ADC PARKS & GREENSPACE ARBORICULTURE

PLANNING APPLICATION: BE/93/15/TC

ADDRESS: Shripney Manor Shripney Lane Bognor Regis PO22 9NU

BRIEF DESCRIPTION: Fell 2 No. Leyland cypress trees, fell 1 No. Leyland cypress hedge & remove re-growth from lower branch stub of 1 No. Holm Oak tree.

BE/93/15/TC

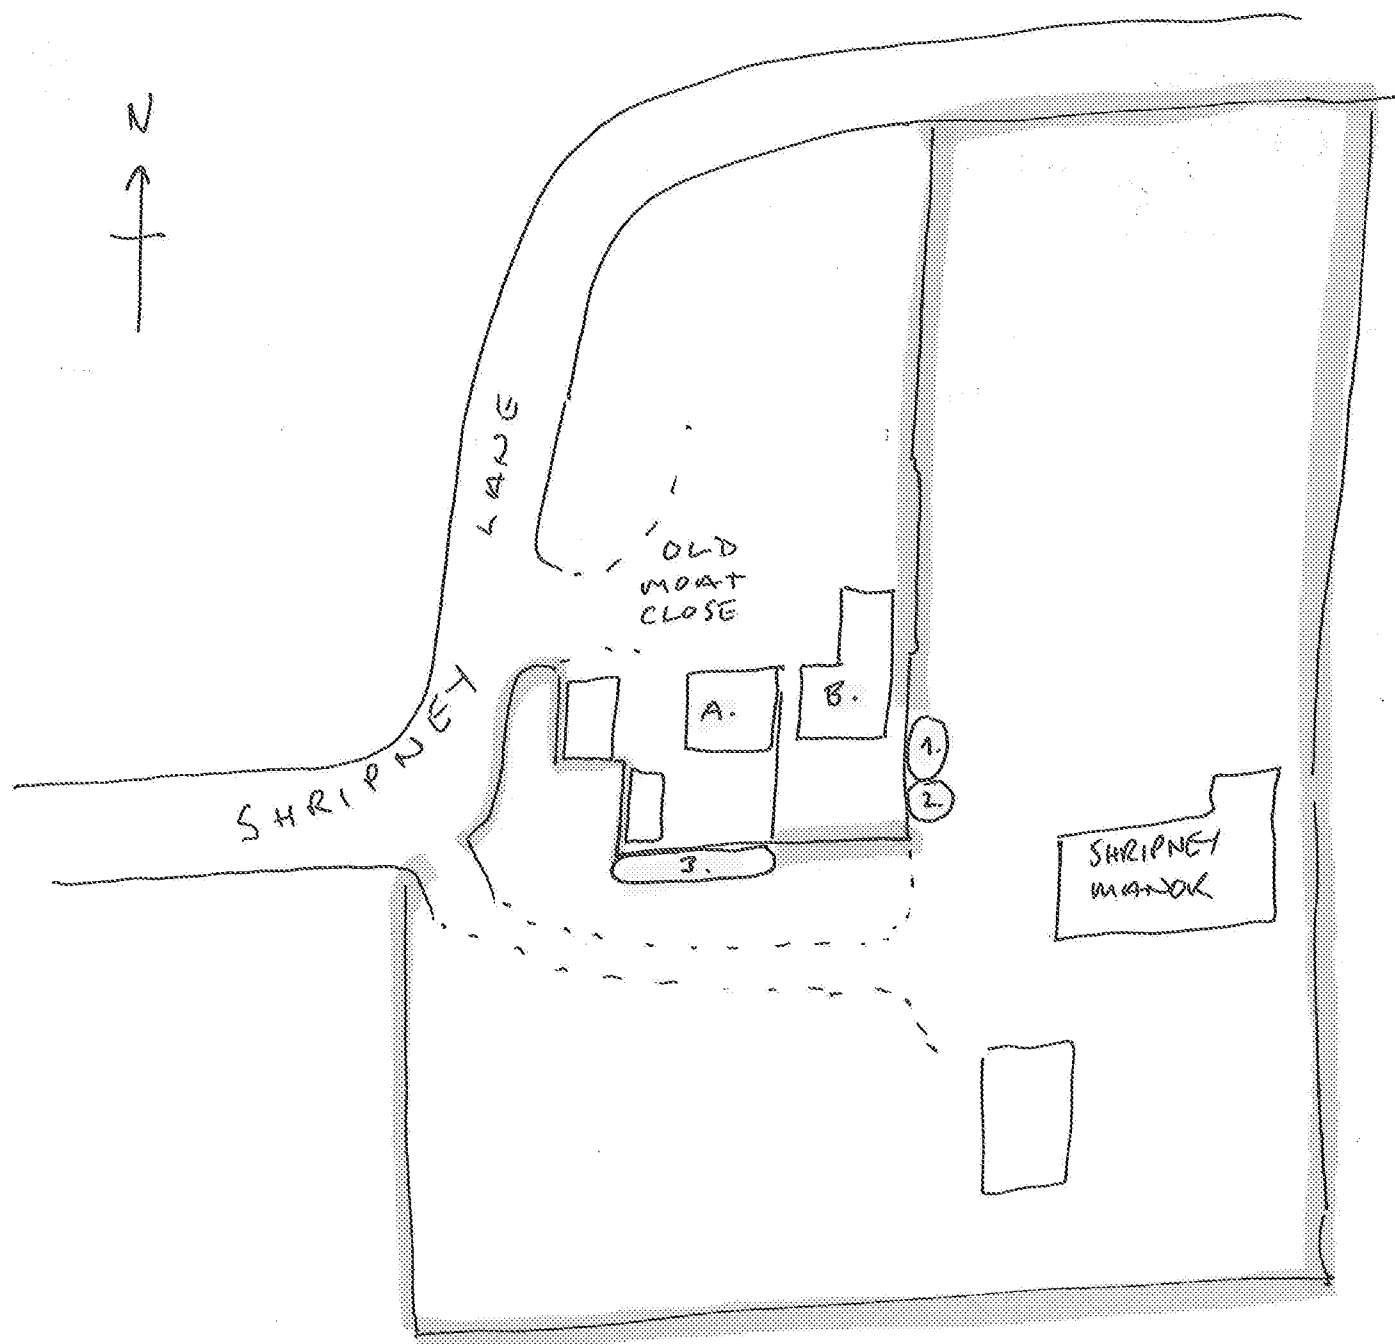
- The trees that have been highlighted in this application are situated in the garden of Shripney Manor, Shripney Lane.
- All trees cited in this application are not covered by active TPO's, however they are standing in a conservation area.
- From the site inspection it is clear that both **T1** and **T2**, are both in poor condition, and are likely to have limited retention spans. This does mean that these trees were not suitable for TPO orders.

- For **T3**, the applicant has applied to remove a low branch stub spanning towards Saxon lodge. The removal of said branch/stub is unlikely to have a negative impact on the aesthetical value and/or the Vitality of **T3**.
- From the site inspection it is clear that **H4** is in poor condition, and is likely to have limited retention span. This does mean that these trees were not suitable for TPO orders.

- As the cited trees are not suitable for TPO orders and/or the proposed operations are unlikely to have a negative impact on the highlighted trees, **I would have no objection to the proposed operations.**
